Application No: K/23/21/HH
Site Address: Mimosas Gorse Avenue East Preston BN16 1SF
Description of works: Erection of part 2 storey and single storey rear extension and first floor balcony

Thank you for your internet representation made on 17th June 2021 which has been recorded as an objection with the comments as follows:

Kingston Parish Council would like to make the below observations:

Job Number: AR-157 Drawing Number: 04 Revision: Revision

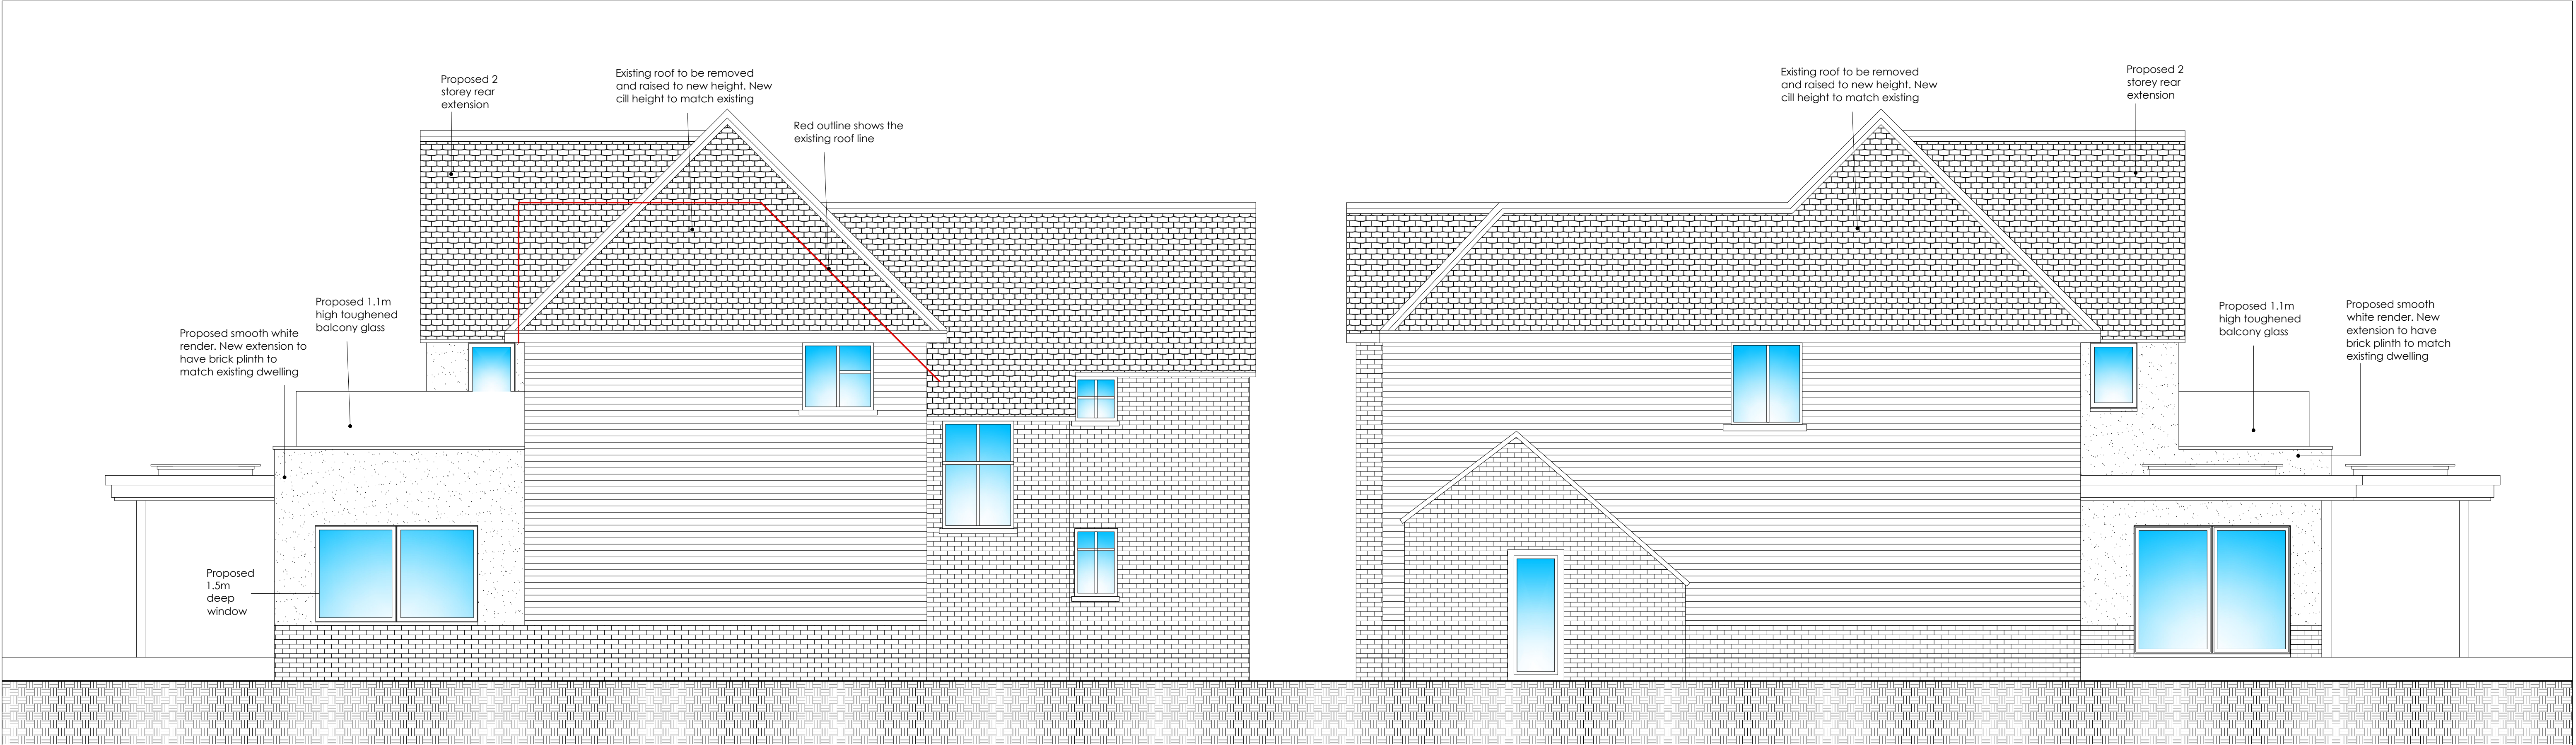
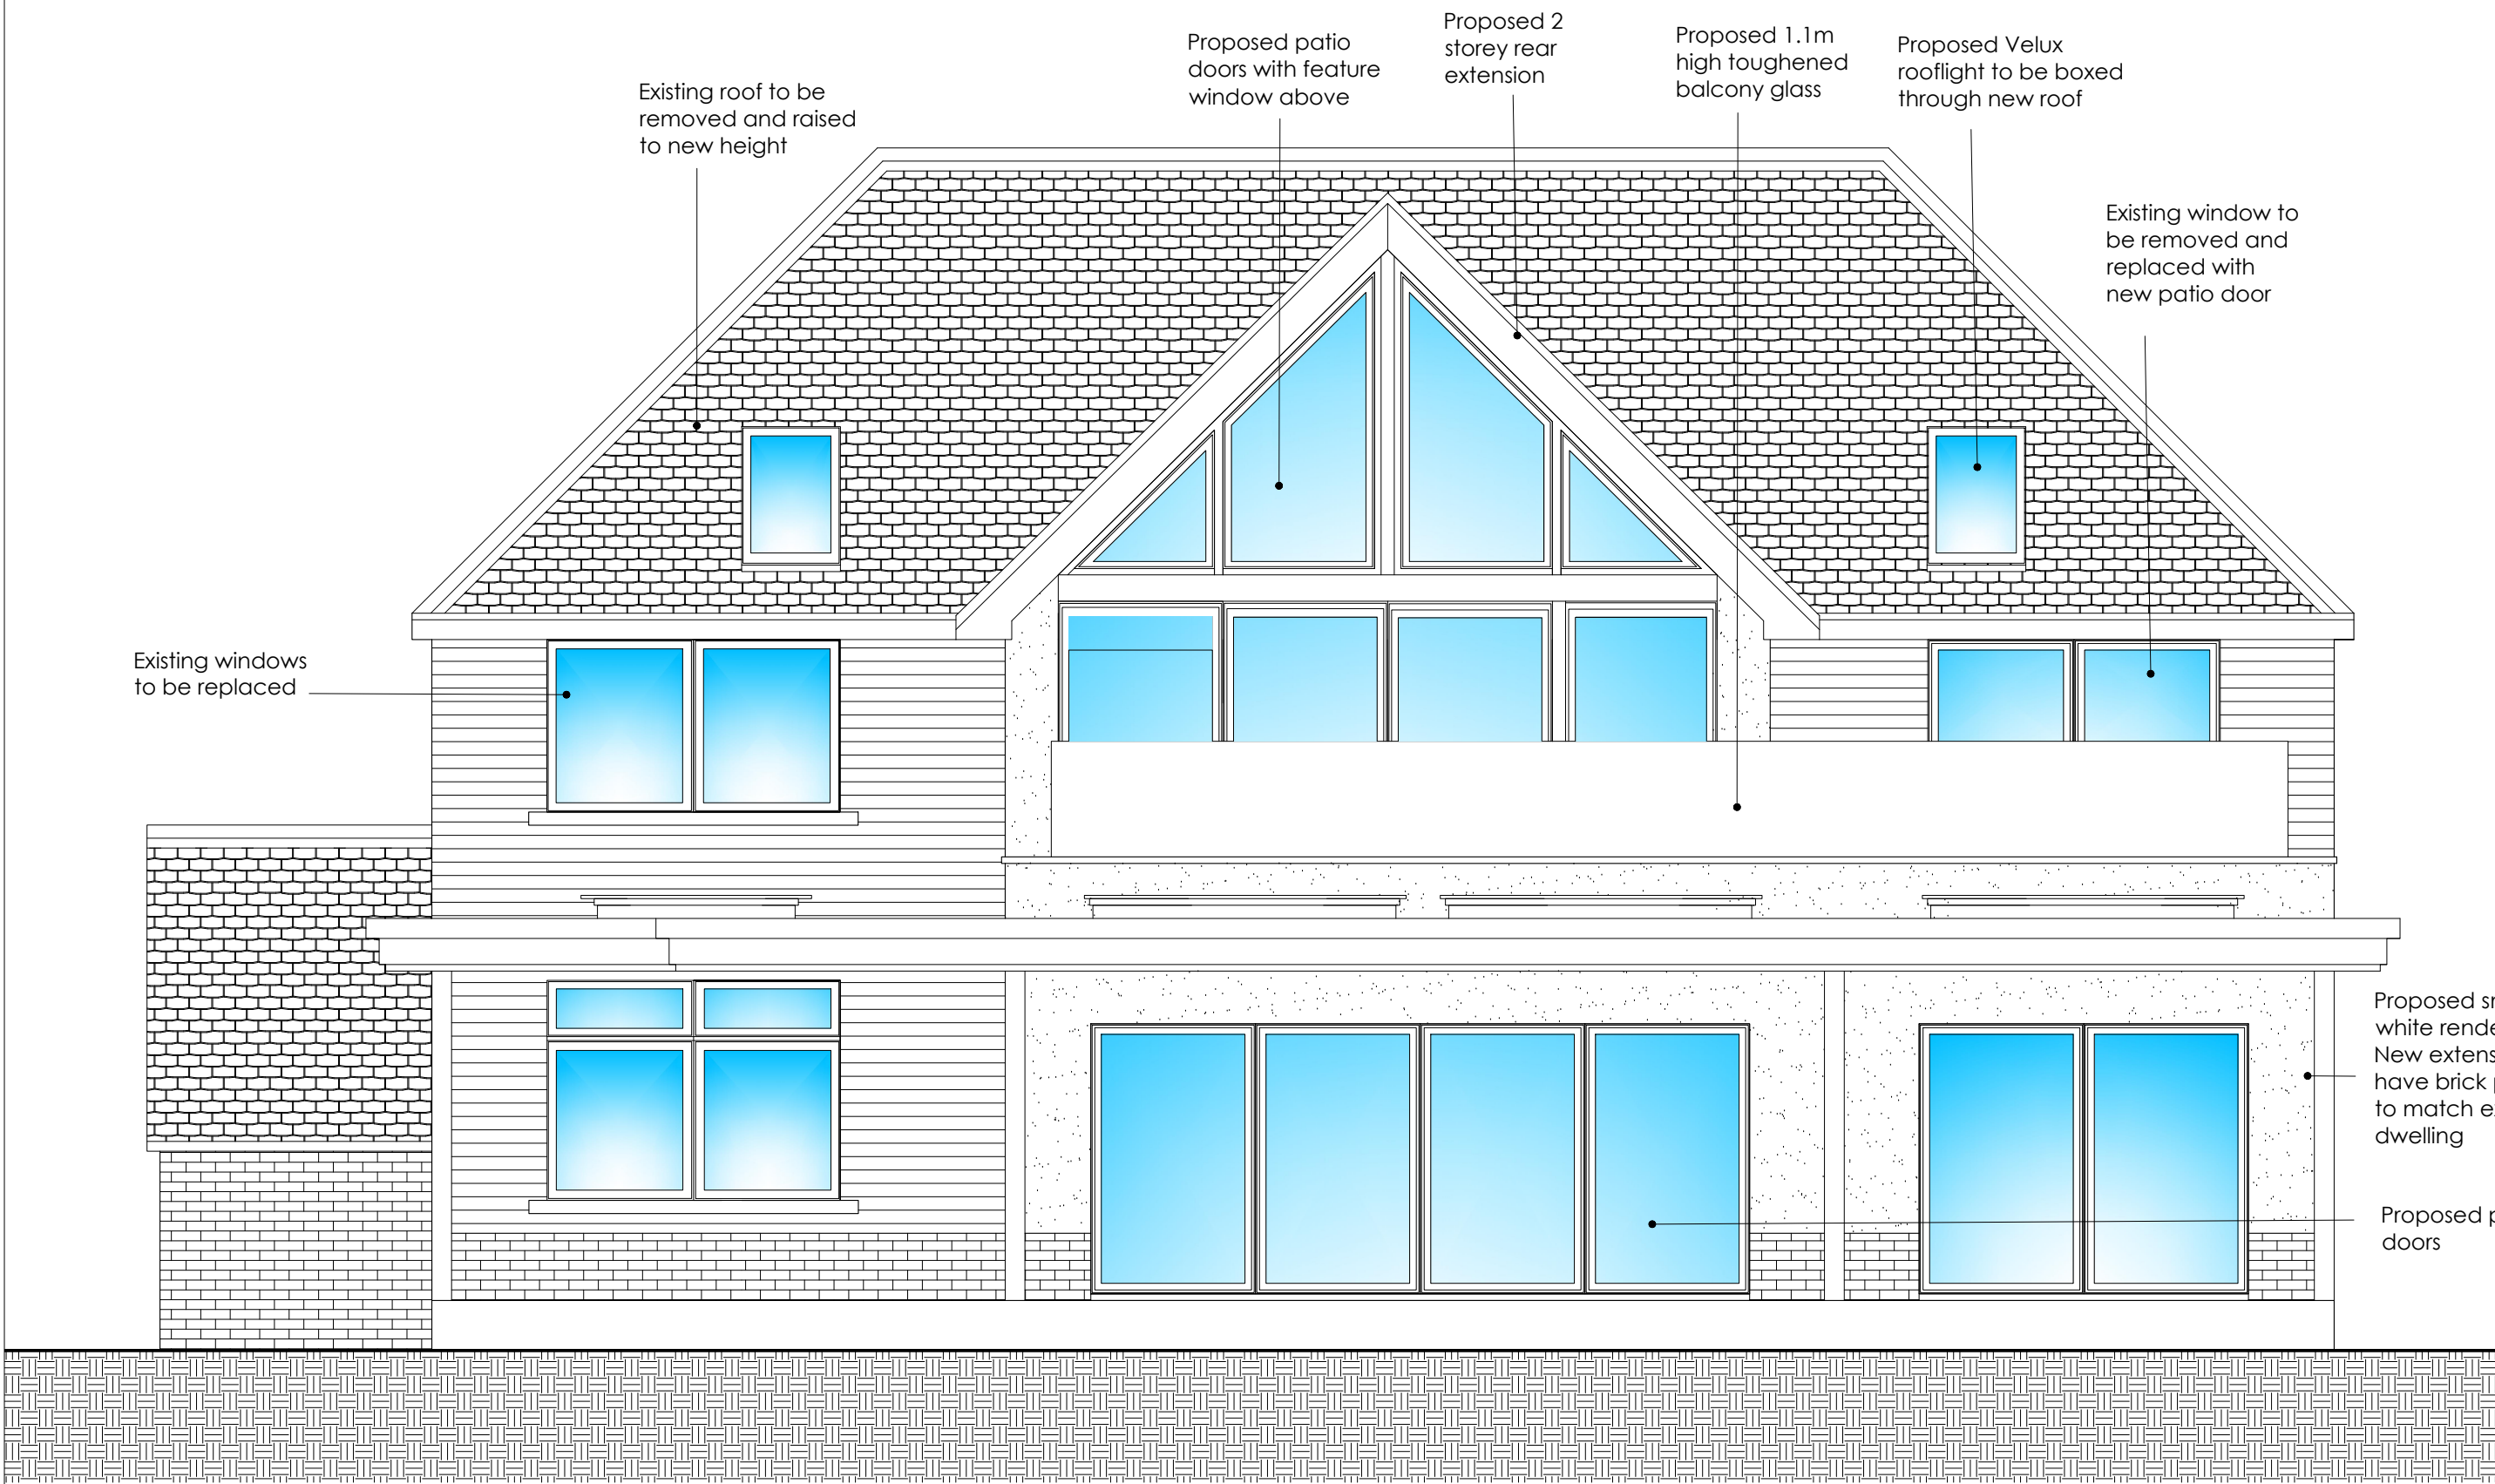
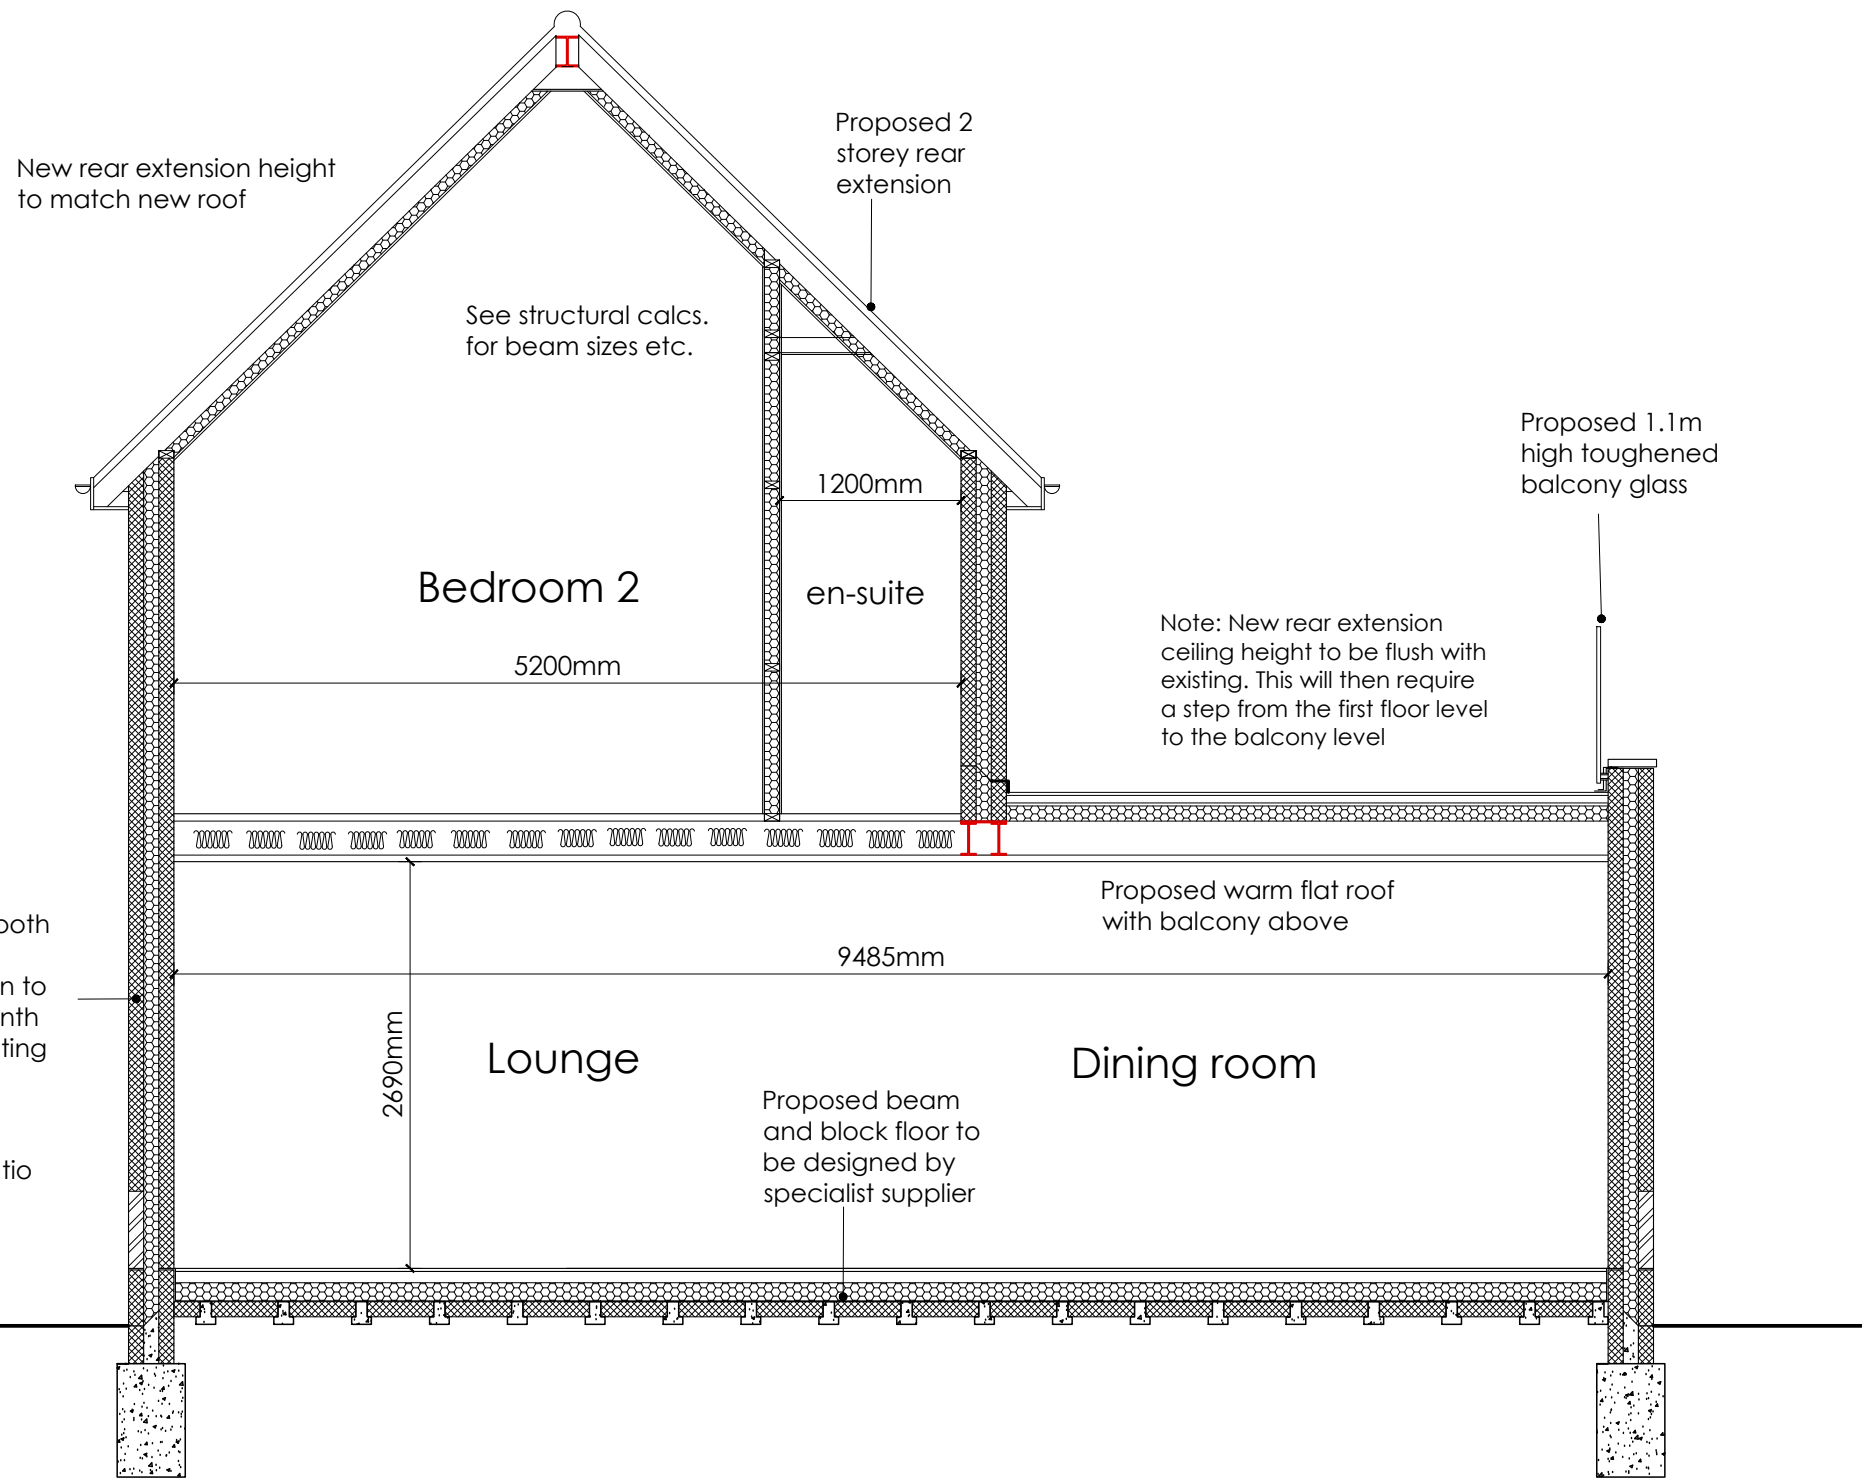
- Ridge height - the ridge height of the new extension is considerably higher than the original, but there are no heights given for the elevations, only the comment "existing survey was undertaken by others, including heights". rough calculations put it higher by nearly 1 metre (900 mm / 35 inches) to the original roof.
- Spring Tide could be overlooked from the new balcony.

1. The ridge height is lower or in line with neighbouring properties, and
2. The balcony does not overlook adjacent properties
